**Date:** 01/22/2025

**Re:** **Framing Items**  
Location: Lot 41 Honeycutt Hills (188 Shelby Meadow Lane. (Angier, NC))  
JDS Project No.: RDU2500605  
Date of Inspection: 01/22/2025

sheet:
S3.0

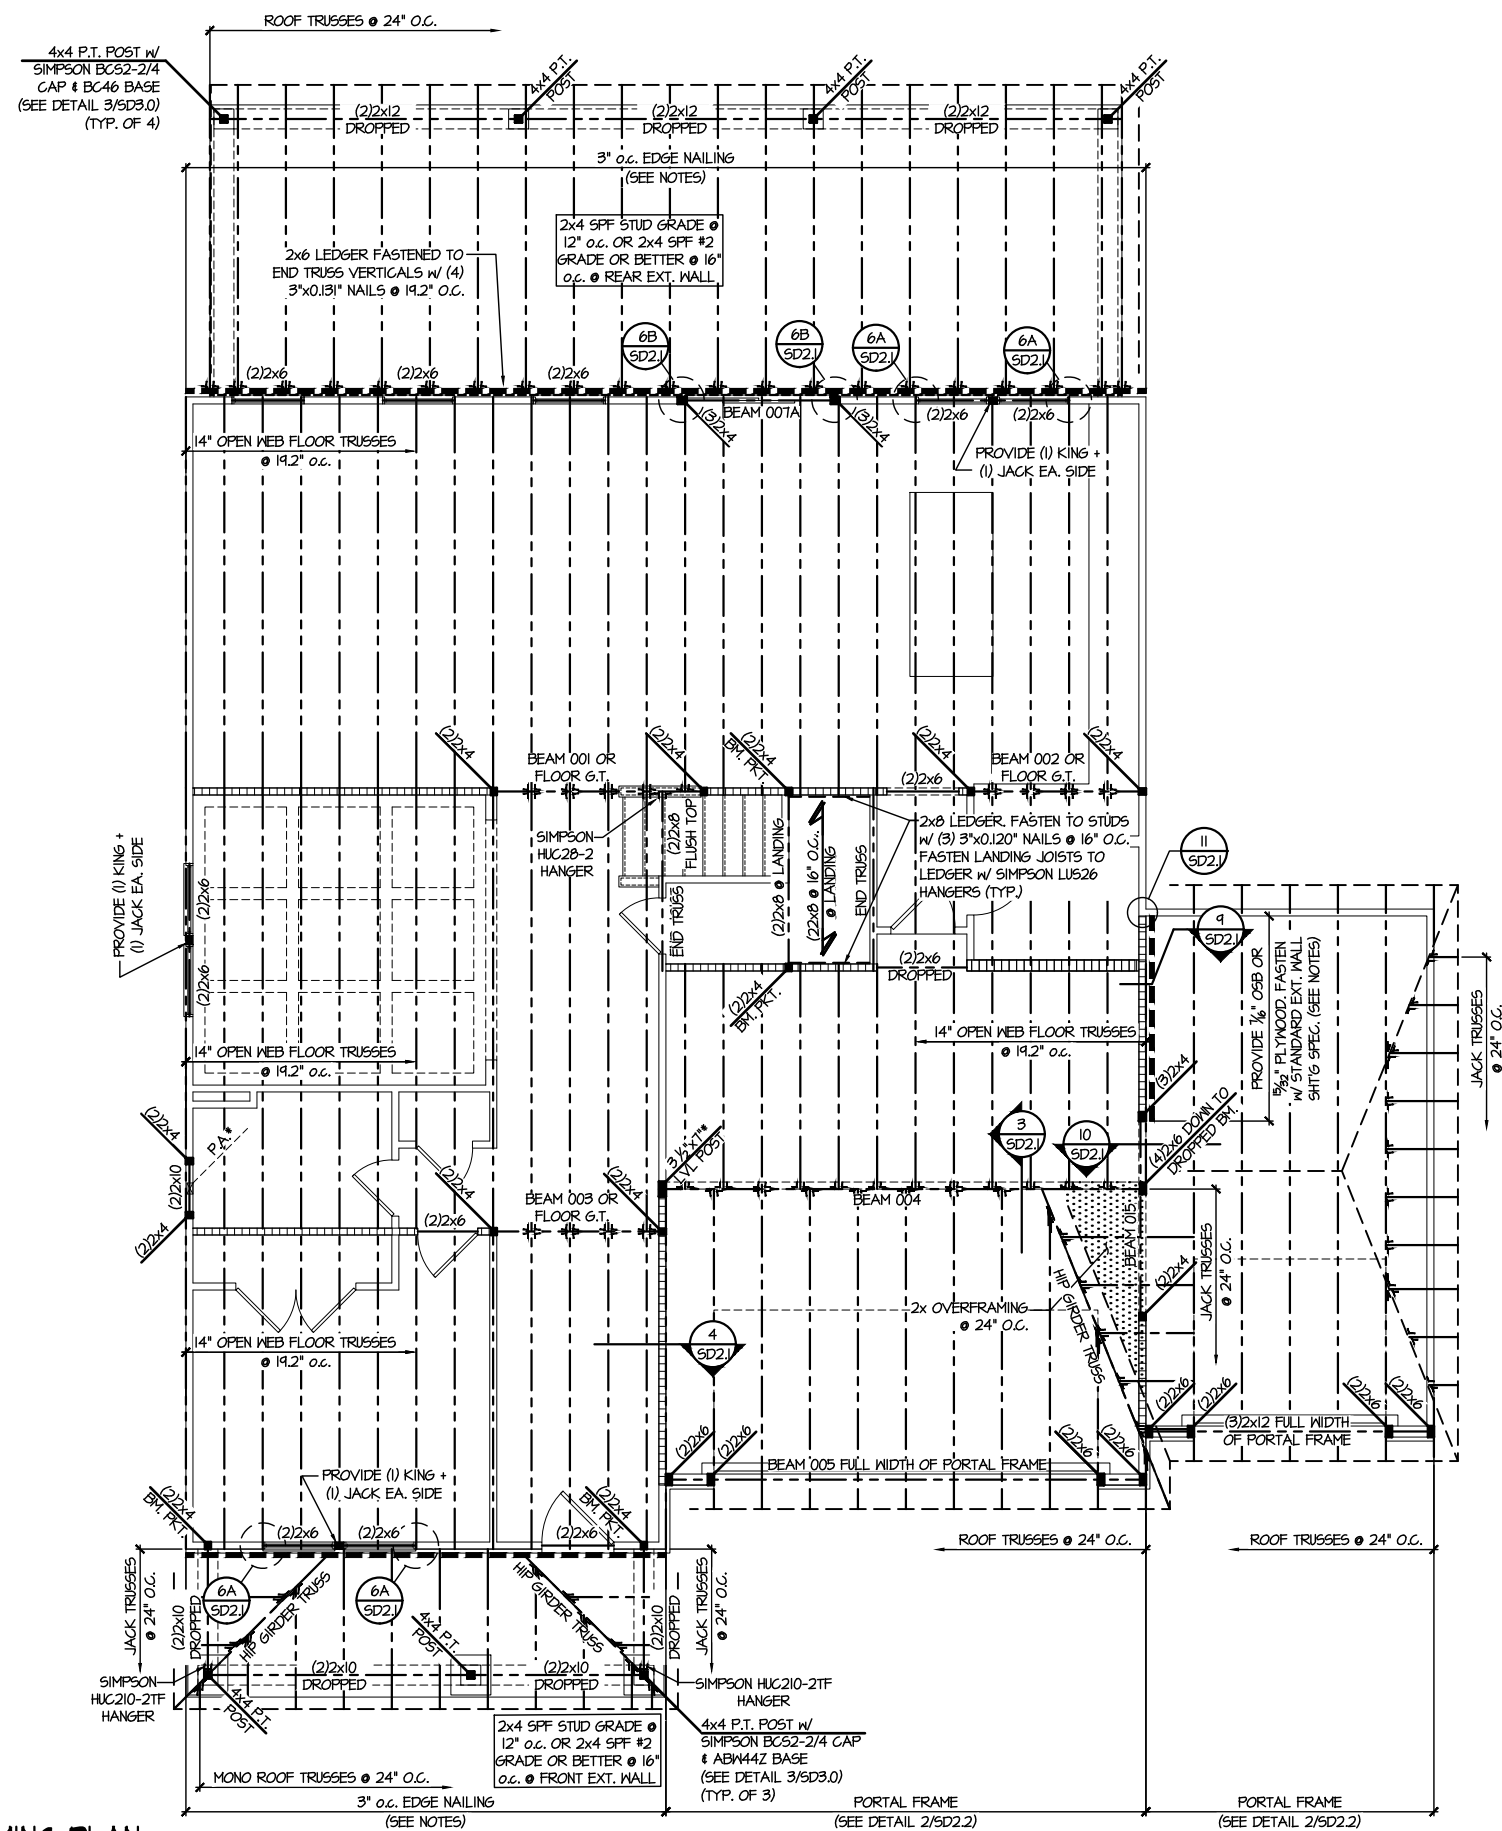
1. The contractor cut approximately 44" of the F209 floor truss between joints 7 and 2, severing the diagonal web and the top and bottom chords. The stair landing bears at the entrance of the storage room at the front of the stairs (non-load bearing wall).
2. Structural page S3.0 calls per Simpson BCS2-2/4 cap for the 4x4 pressured treated. Due to the orientation of the beam, the post cap has not been installed properly.

2. At the exterior sides of the 4x4 pressure-treated posts, install (1) LCE4 Simpson post cap (two in total per post) and secure them according to the manufacturer's instructions.
